# Memorandum

**To/Attention** Vincent Denomme **Date** May 9, 2023  
**From** Lindsay Jackson **Project No** 140253  
**cc** Alex Zeller  
**Subject** Walkley & Conroy Tree Conservation Report Comment Response Table

**Figure: 3.1**

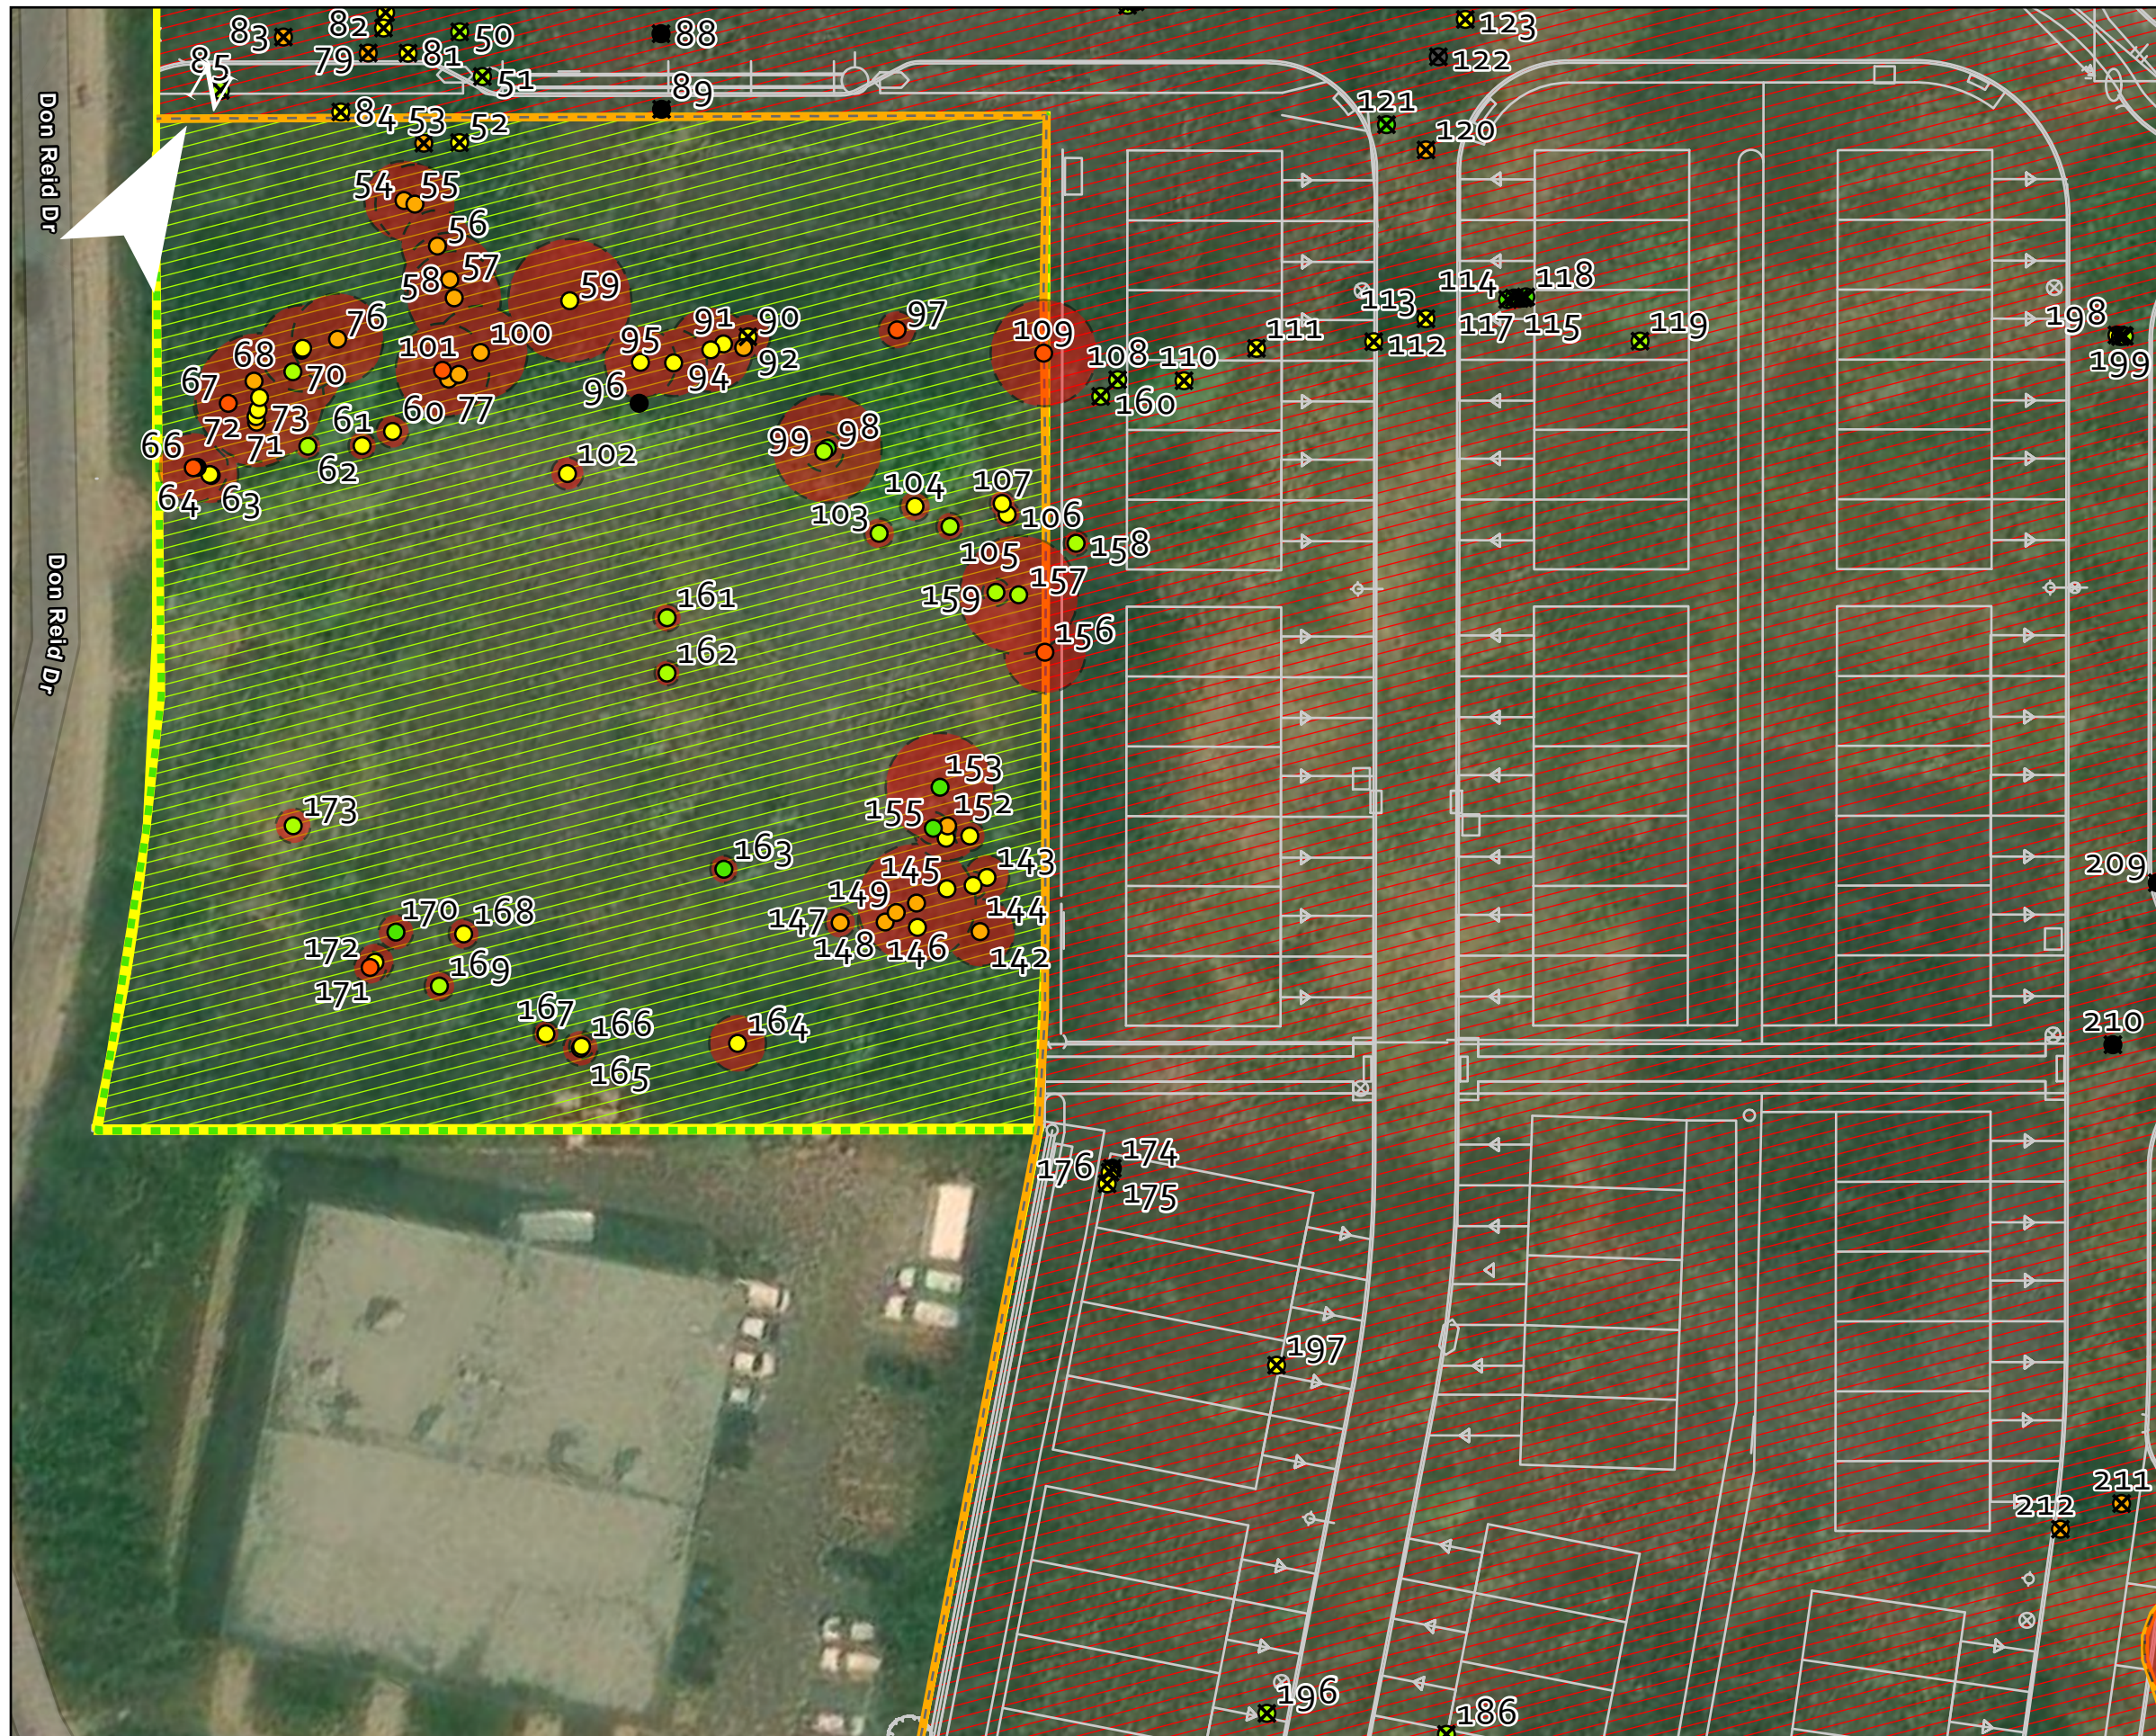
<p>9. Tree Removal in the area identified as “Additional lands owned by the applicant” in the Planning and Design Brief will not be approved through this Site Plan Control application. Tree removal will be considered at the time of the future development’s Site Plan Control application. Please update the TCR showing the trees in this area as retained.</p>	<p>We have obtained an update Site Plan and have updated our figures to reflect the update. Trees that are not within the Subject Property or are not expected to be impacted by the works associated with the property development have been removed from the mapping and the inventory table to avoid any confusion. Any trees that are within this area, and whose critical root zone conflicts with development have been identified.</p>
<p>10. There are 266 trees identified for removal with the reasoning presented in the TCR being they are mostly non-native and invasive species. Non-native species can serve an important function in the urban forest. Removal because a tree is non-native is not justified. Retention solutions for healthy trees in suitable locations must be sought. Please consider retention strategies for trees where feasible with a focus on exploring options for tree #s 1, 99, 110, 221-224,225, 229, 231,234,237, 239, 245 – 247, 248-250, 254, 253.</p>	<p>Retention strategies have been explored for the following trees: 1, 99, 110, 221-224,225, 229, 231,234,237, 239, 245 – 247, 248-250, 254, 253. Please see Table 2 for provided tree-specific rational in relation to the provided Site Plan.</p>

<b>Tree ID #1</b>	Updated Site Plan shows that this tree can be retained. Tree protection fencing will be required to protect the CRZ as it borders the property line.
<b>Tree ID #99</b>	Updated Site Plan places this tree within the proposed park block. As there is no detailed design available for the proposed park, the tree can be retained. Tree removal details for the park will occur at the detailed design stage, and trees identified by the City should be considered for incorporation in the design.
<b>Tree ID #110</b>	Updated Site Plan places this tree within the footprint of a home and is not suitable for retention. Tree is to be removed.
<b>Tree ID #221-224</b>	Updated Site plan identifies this section of trees as retainable. Tree protection fencing will be required to protect the CRZ.
<b>Tree ID #225</b>	Updated Site Plan shows that this tree can be retained. Tree protection fencing will be required to protect the CRZ as it borders the property line.

<b>Tree ID #229</b>	Updated Site Plan shows that this tree can be retained. Tree protection fencing will be required to protect the CRZ as it borders the property line.
<b>Tree ID #231</b>	Updated Site Plan shows that this tree cannot be retained as it is within a road right-of-way.
<b>Tree ID #234</b>	Updated Site Plan shows that this tree cannot be retained as it is within a road right-of-way.
<b>Tree ID #237</b>	Updated Site Plan shows that this tree cannot be retained as it is within a road right-of-way.
<b>Tree ID #239</b>	Updated Site Plan shows that this tree cannot be retained as it is within a road right-of-way.
<b>Tree ID #245-248</b>	Updated Site Plan shows that this tree can be retained. Tree protection fencing will be required to protect the CRZ.
<b>Tree ID #249</b>	Updated Site Plan shows that this tree cannot be retained as it is within a parking lot.
<b>Tree ID #250</b>	Updated Site Plan shows that this tree cannot be retained as it is within a parking lot.

<b>Tree ID #253</b>	Updated Site Plan shows that this tree cannot be retained as it is within a parking lot.
<b>Tree ID #254</b>	Updated Site Plan shows that this tree cannot be retained as it is within a parking lot.
